City of Portland, Maine - Building or Use Permit Application
 389 Congress Street, 04101 Tel: (207) 874-8703, Fax: (207) 874-8716

Permit No: 09-0642	Issue Date:	CBL: 109C A037001
------------------------------	--------------------	-----------------------------

Location of Construction: 370 SUNSET RD Cliff Island	Owner Name: COLESWORTHY PETER L	Owner Address: 30 BRISTOL LN	Phone:
Business Name:	Contractor Name: Eric Anderson	Contractor Address: P.O. Box 91 Cliff Island	Phone 2077665744
Lessee/Buyer's Name	Phone:	Permit Type: Additions - Dwellings	Zone:

Past Use: Single Family Home	Proposed Use: Single Family Home - new 336 sq ft screened porch, 208 sq ft 1 story addition, enlarge existing bedrooms, add bathroom, & 68 sq ft entry porch addition	Permit Fee: \$620.00	Cost of Work: \$60,000.00	CEO District: 1
Proposed Project Description: new 336 sq ft screened porch, 208 sq ft 1 story addition, enlarge existing bedrooms, add bathroom, & 68 sq ft entry porch addition		FIRE DEPT: <input type="checkbox"/> Approved <input type="checkbox"/> Denied	INSPECTION: Use Group: Type	
		Signature:	Signature:	
PEDESTRIAN ACTIVITIES DISTRICT (P.A.D.)				
Action <input type="checkbox"/> Approved <in

**BOUNDARY SURVEY/SITE PLAN**  
 AT CLIFF ISLAND AVENUE, PORTLAND, MAINE

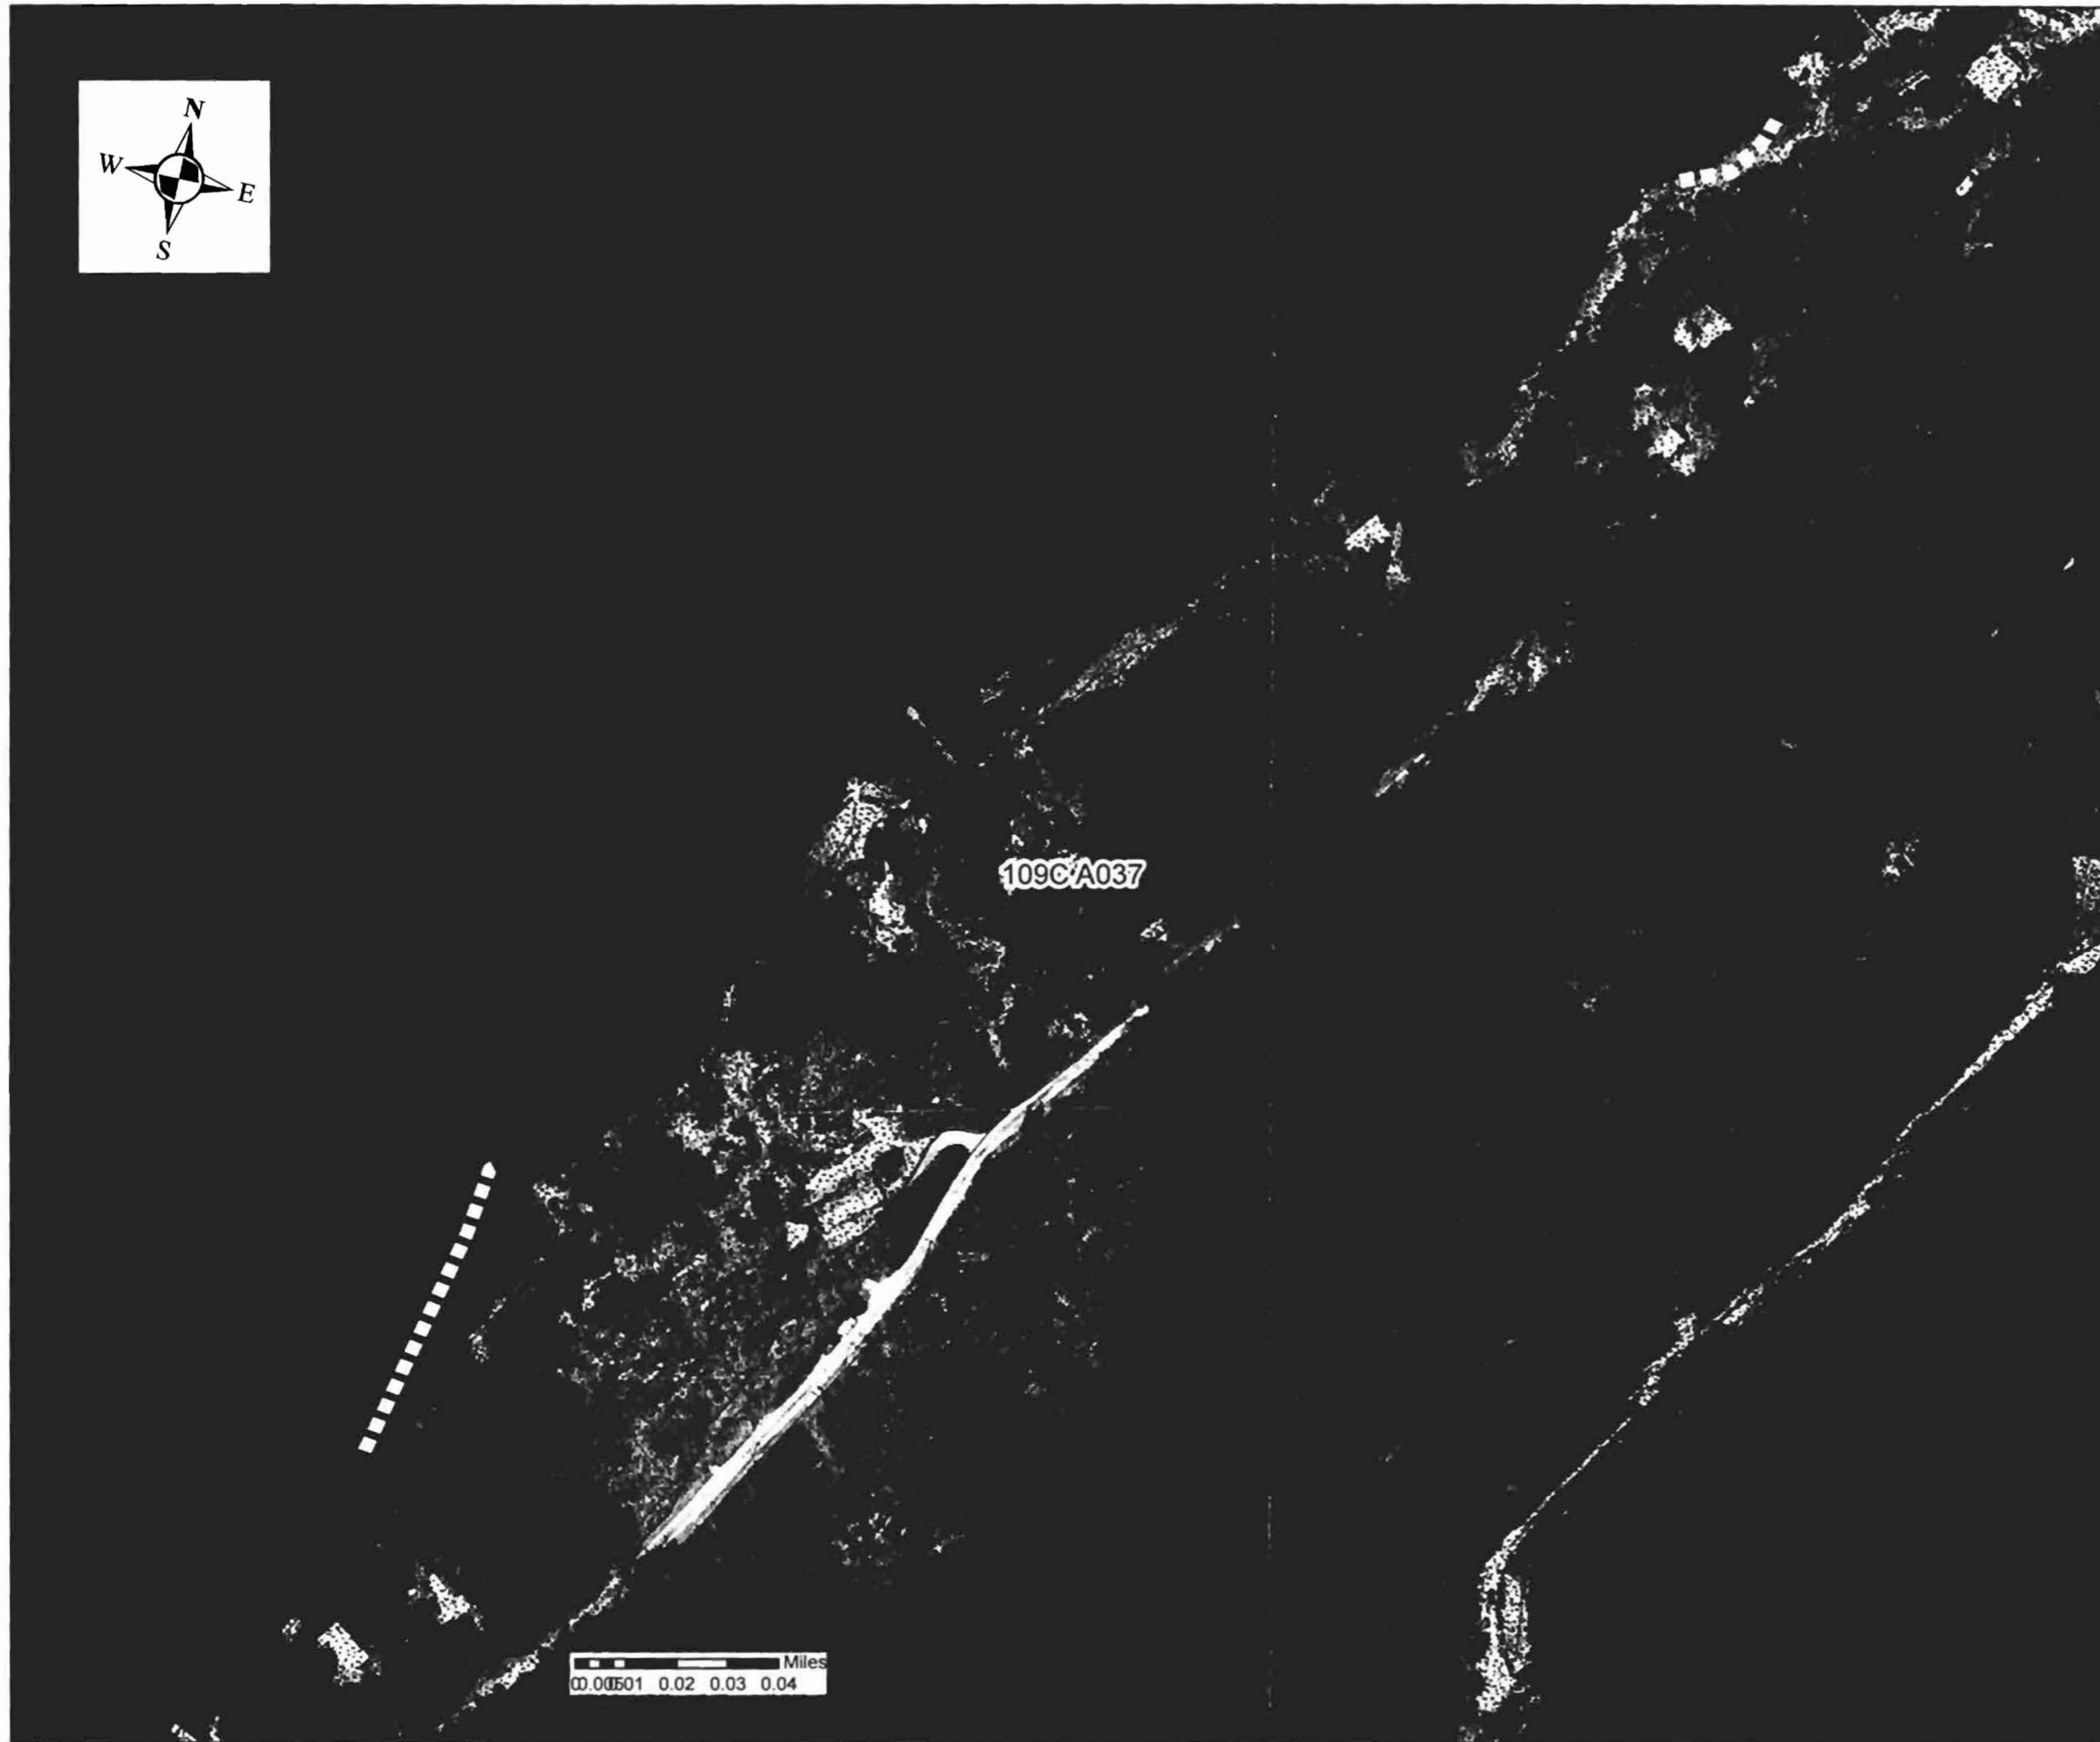
6/26/2009-amachado: Left message For Steve Blatt. Deck on A1.1 "existing deck to remain is not permitted & within 75' setback. Need updated survey of location of 75' setback from highest tide for 2009.

7/1/2009-amachado: Spoke to Steve Blatt. Told him that the existing deck was not permitted. Told him that the 75' shoreland setback was located in 2006. Upland edge of coastal wetland is based on area that is subject to tidal action during max. spring tide as identified in tide tables published by national Ocean Service. Since the additions are close to the 75' setback, need to know what it would be for 2009 based on the tide tables for 2009. He said that he would pass the information on to the owner.

9/15/2009-amachado: Received revised siteplan on 9/9/09 that showed 75' setback for shoreland and the proposed additions. Went over them with Steve Blatt today.

1 MID & LOWER LEVEL FLOOR PLAN
SCALE: 1/4" = 1'-0"

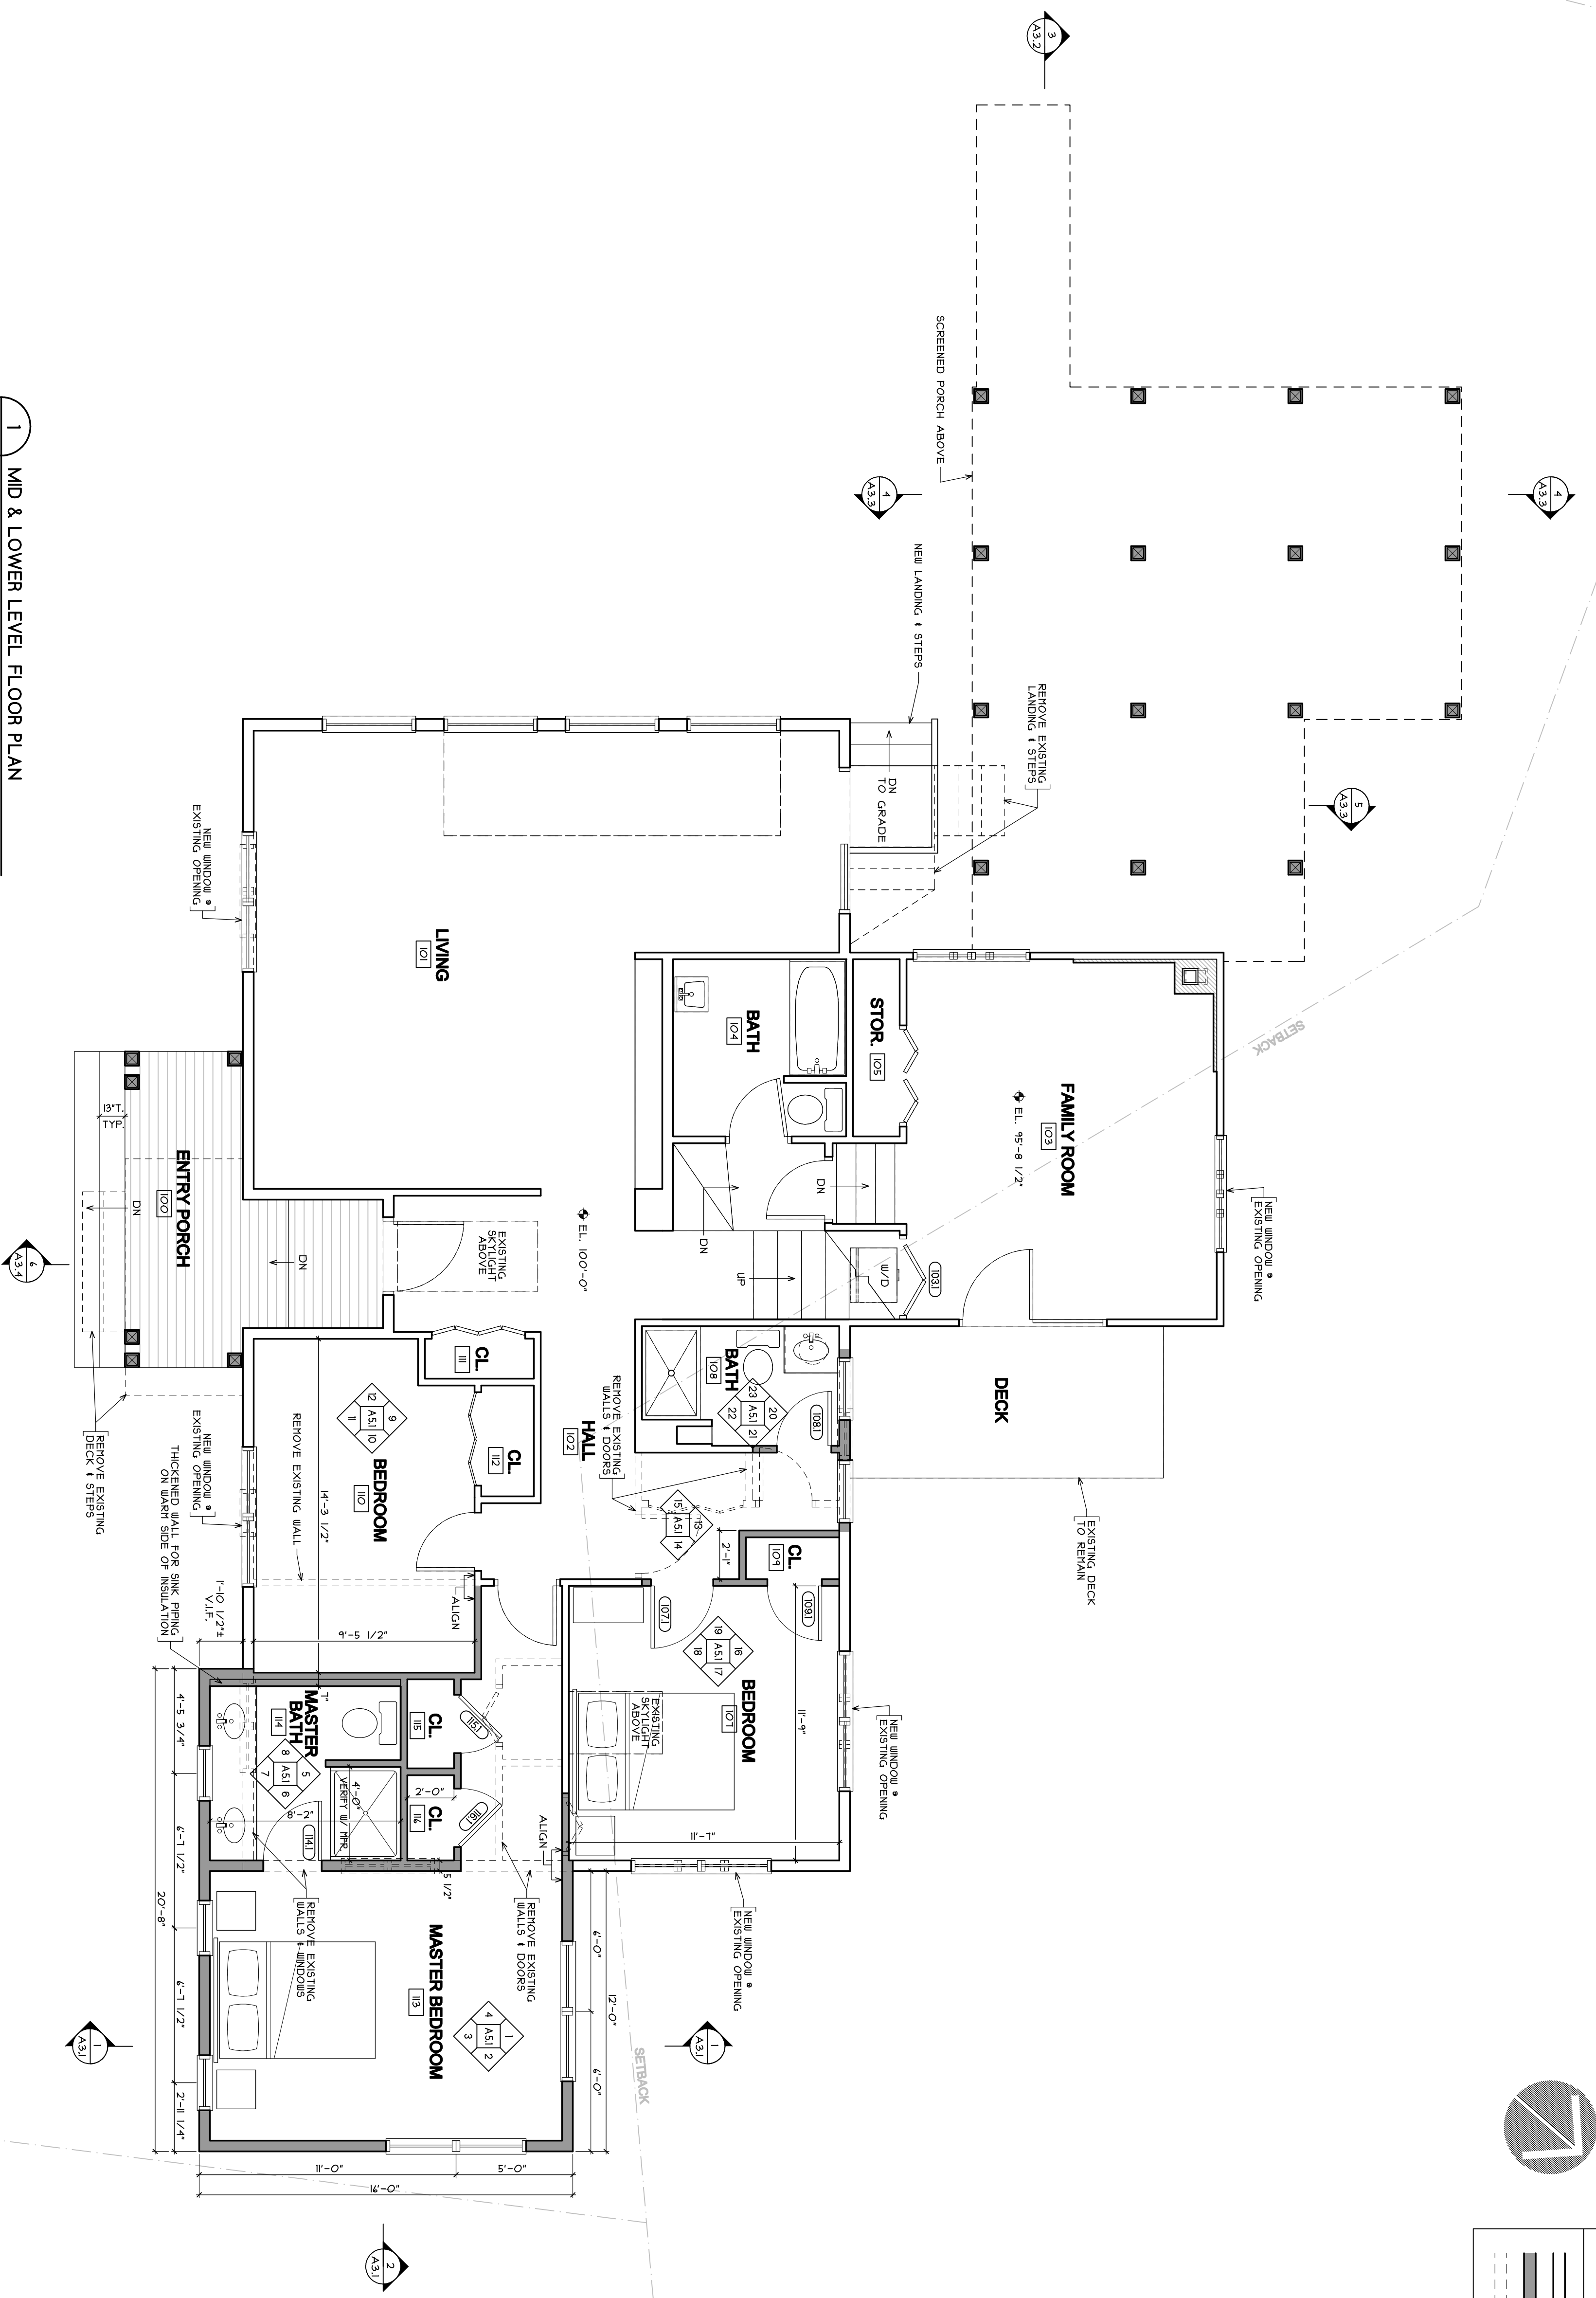
7/8/2009-amachado: Spoke to Peter Colesworthy. He had no idea that the deck was not permitted. It will be removed and be replaced by steps to grade per code. New plans will be submitted that show this. He is planning to contact Bob Greenlaw to update the 75' setback from the highest annual tide to make sure that the proposed additions are outside the 75' setback.
